Consultation Response from KC, Conservation & Design
2026/90868 Land north of, 39, Hightown Lane, Holmfirth, HD9 3HY
Erection of detached dwelling (part within a Conservation Area)
Date Responded: 5/6/26
Responding Officer: SC
Responding Ref:

Drawing Number
OP-I300-DR-200-01
 Drawing Title
Overview Plans

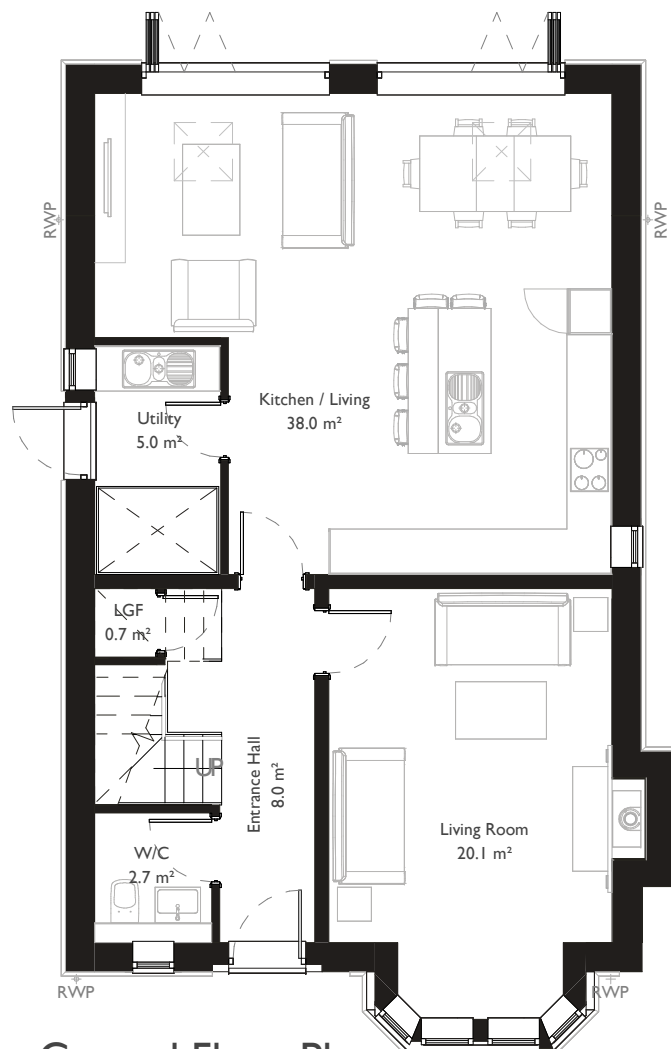
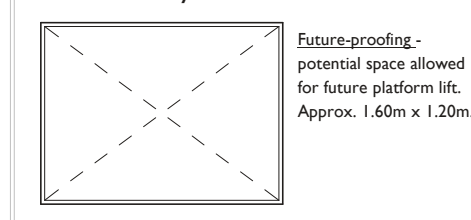
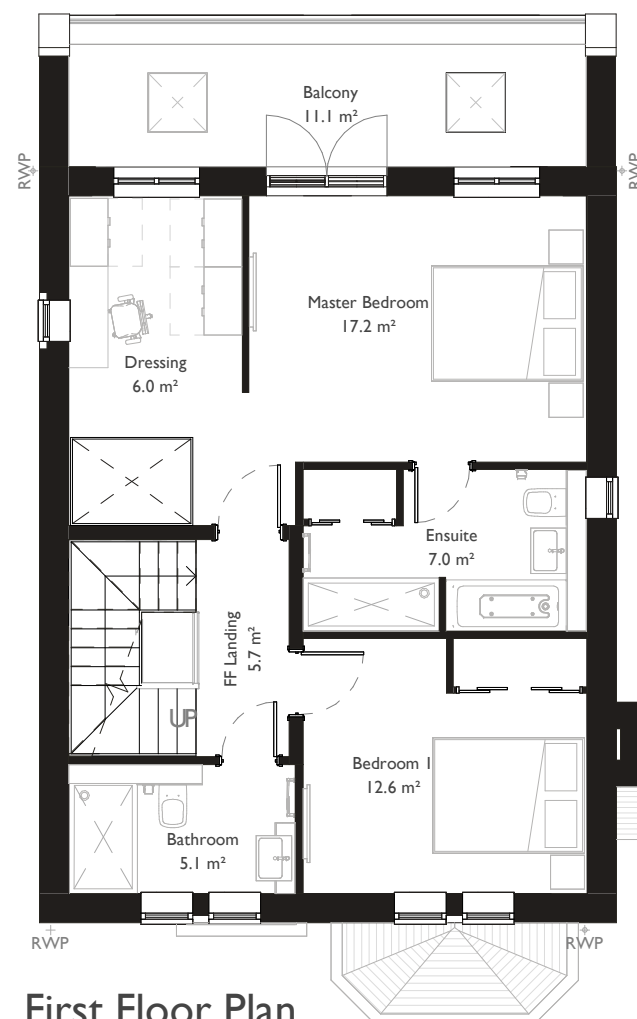
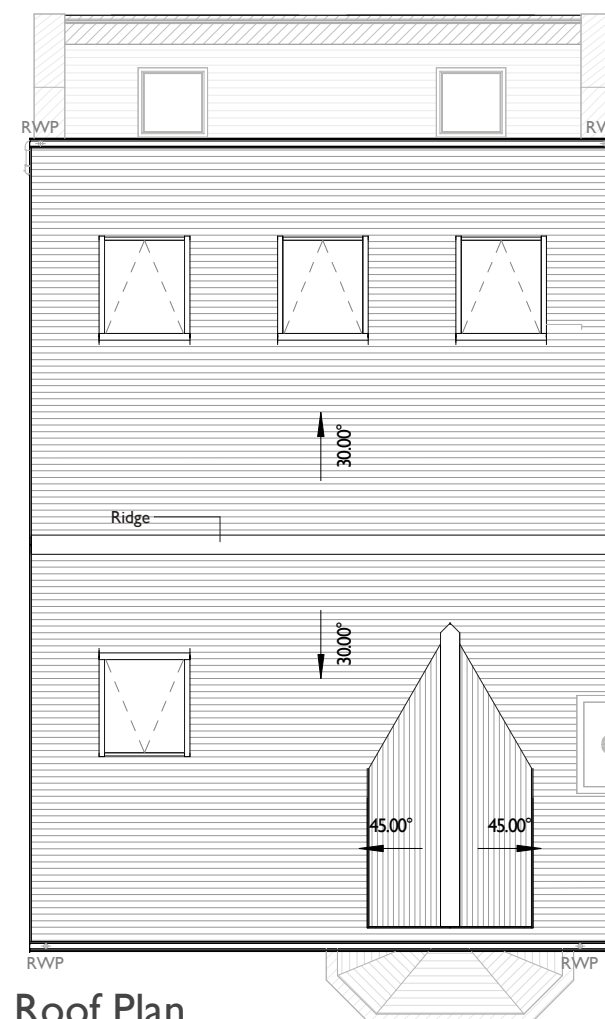
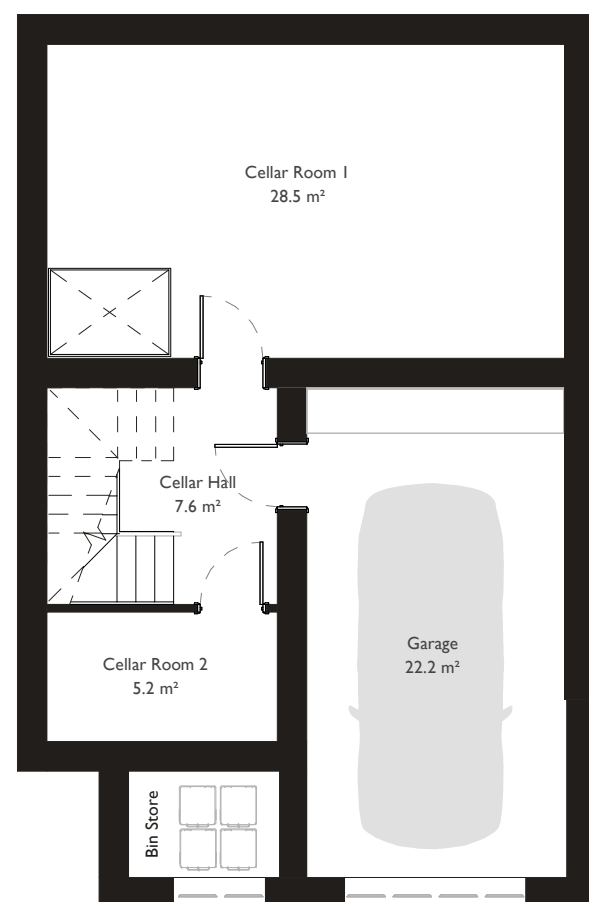
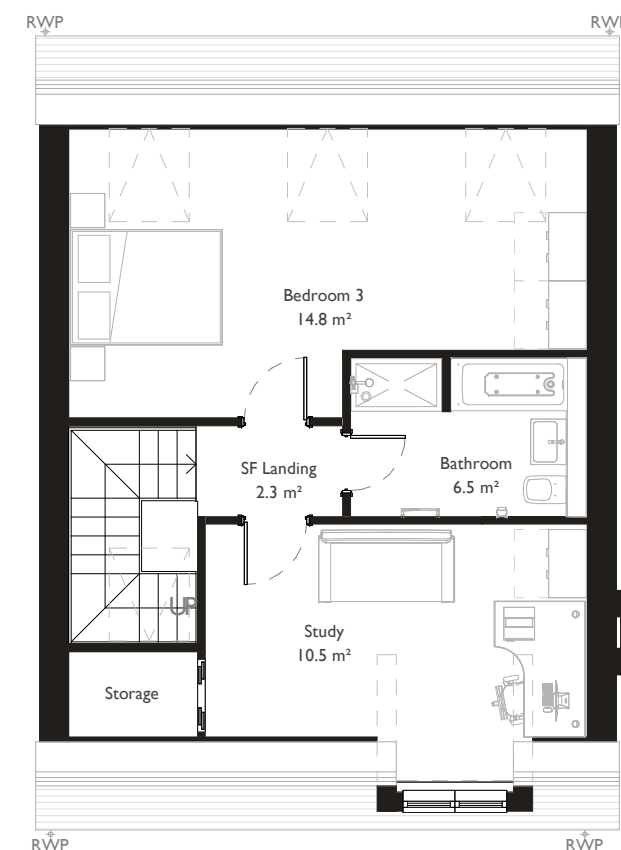
The new dwelling should be no higher than the adjacent existing dwelling.

The current proposal is for a three storey dwelling (including a substantial basement). The appearance is quite dominating in the street scene due to the three-storey height with the substantial basement. The lack of soft landscaping and front boundary wall would also contribute to this dominance.

- Could the basement be reduced in height, thereby also reducing the eaves height.
- Reduce the dominance of harsh use of solid materials at basement level – are there any options for soft landscaping to soften the appearance to blend in with the Conservation Area and to compensate for loss of trees/greenspace at this site.
- Reduce height and width of dormer, check cladding materials to be appropriate.
- Align the front door with the upper windows above.
- Align roof light with windows below.
